My comments on the Applicant's responses (in REP6-070) to my Open Floor Hearing statement REP6-106 (Linda Twohey)

**I asked the Applicant to clarify what route construction traffic would take to access fields AF2,3 and 4 to erect ground-mounted solar arrays.**

Title:
Figure 8.1.1 Site Locations and Study Area
Green Hill A & A.2

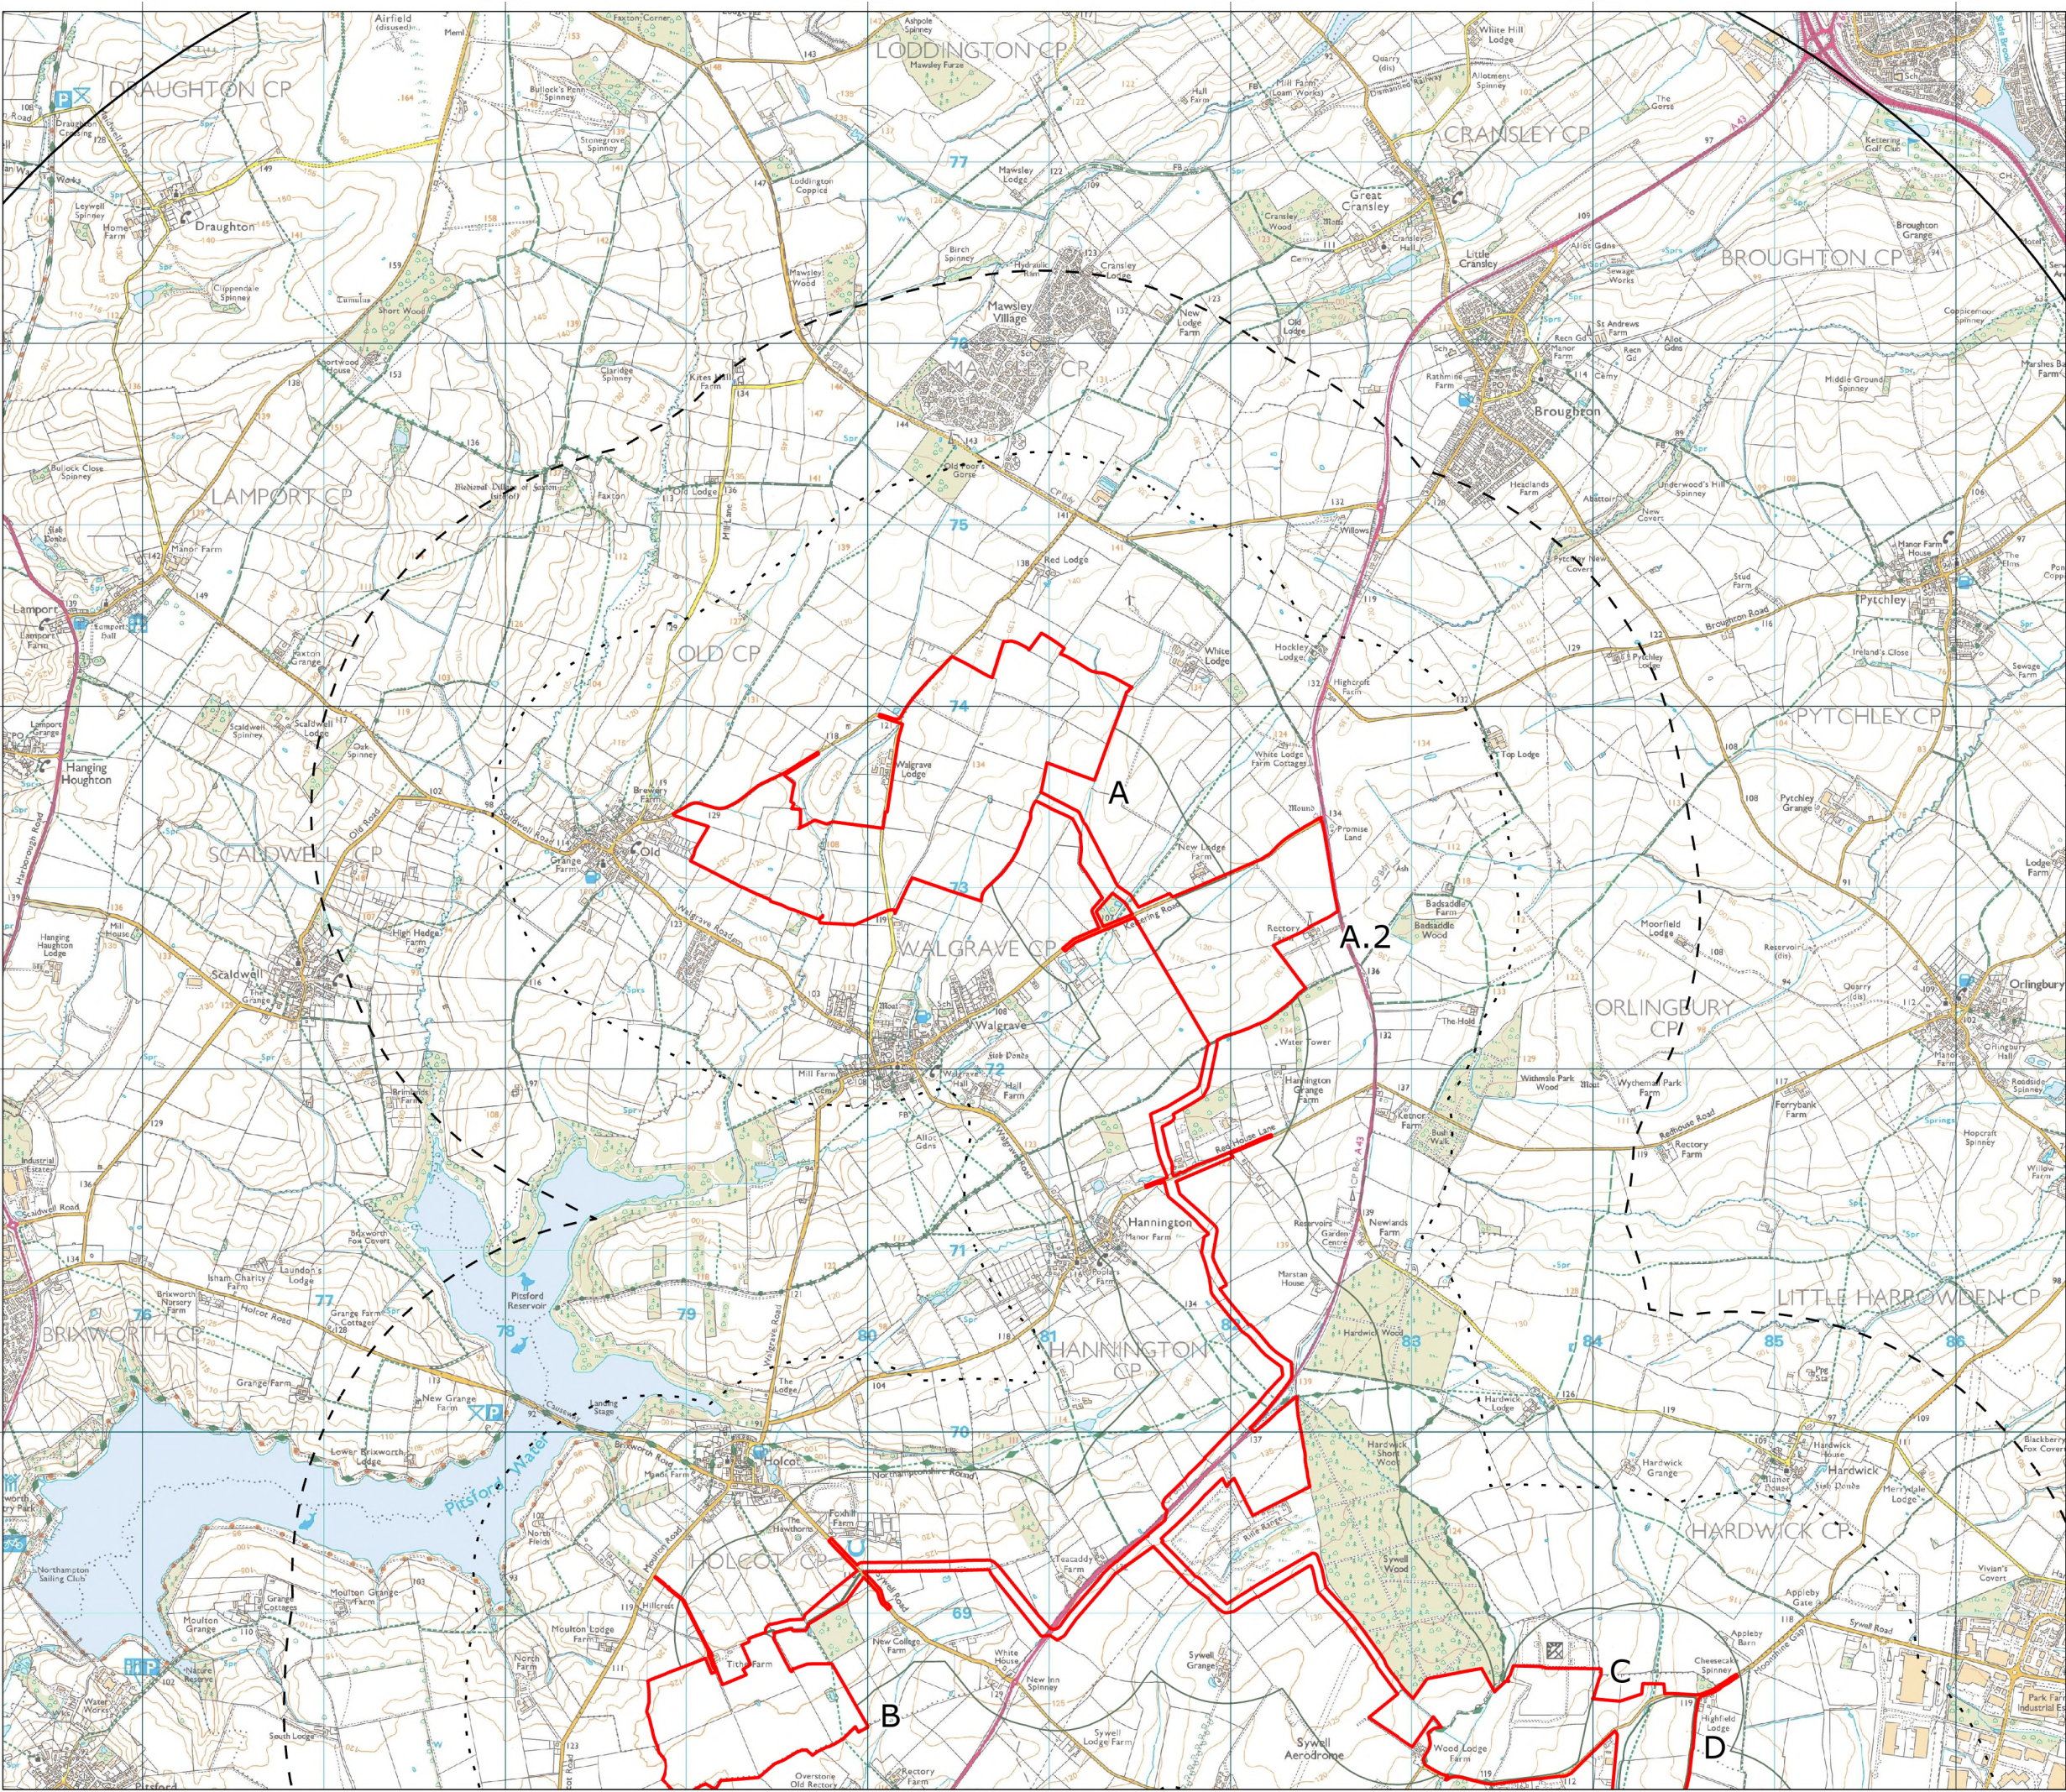
- 1) I have attempted to ascertain the situation regarding the bridge across the watercourse. I cannot access any of these fields directly as they are private property, but viewing from various points along Newland Road and the Broughton Road shows that the watercourse is within a deep channel with abundant vegetation surrounding it, and is fenced off on both sides. However, satellite images show that there are tracks which lead between opposite sides of the 2 smaller watercourses between AF9 - AF7, and AF7 – AF8. It is not possible to substantiate the state of any bridges, but any existing will not have been made to support HGVs, as the Applicant states would use them. Tractors weigh up to a maximum of 10 tonnes, HGVs are typically 32 tonnes.

- 2) The satellite images I have seen also show clearly track routes made by farm vehicles around these fields, AF2,3, and 4. These images show that at present these fields are accessed from the Broughton Road, where a farm track already exists.
- 3) There is no logic in the Applicant's choice to construct new tracks for HGVs through fields which are designated on CR2-008 for 'existing vegetation to be retained and enhanced' (AF7,8) and for 'damp grassland' (AF5), instead of just improving already existing farm tracks on a much shorter and direct route from the Broughton Road Access A-2.
- 4) Their choice of route will cause unnecessary significant harm to a proven ecologically important watercourse, and result in unnecessary significant disruption and disturbance to the designated Quiet Lane, Newland Road, so important to the villagers for recreation.

**As in my OFH2 submission, REP3-114, I asked for justification for not using Access A-2 on the Broughton Road near Old for construction in these fields, the obvious and much shorter route.**

- 1) On map CR2-008, it can be seen that the access track route from Access A-2 starts in field AF1, but after a short stretch turns into AF2, and then through AF2 to AF3 and 4. Any access route coming from Access A-1, would have to travel

through fields AF29, across Newland Road, then presumably through AF10, AF9, across the 2 parts of the watercourse, and at least AF6 to reach AF4. This is a much longer route. With reference to APP-091, page 102, the Indicative Skylark Territory cores are shown across all these areas, and so many more skylarks would be disturbed by their proposed route than my alternative.

*Fields AF2 to AF4 will be accessed via internal tracks from Access A-1 (West), and an existing bridge over the stream will be utilised to connect Field AF9.*

*During construction, vehicles accessing the western area will enter from Broughton Road and travel via internal tracks to the crossing point. The types of vehicles using the crossing may include HGVs, LGVs, cars and shuttle buses.*

*Access A-2, Broughton Road, is proposed for operational use only and will not be used during construction. This reduces the risk of disturbance to skylarks within AF1, which will be retained as a mitigation field.*
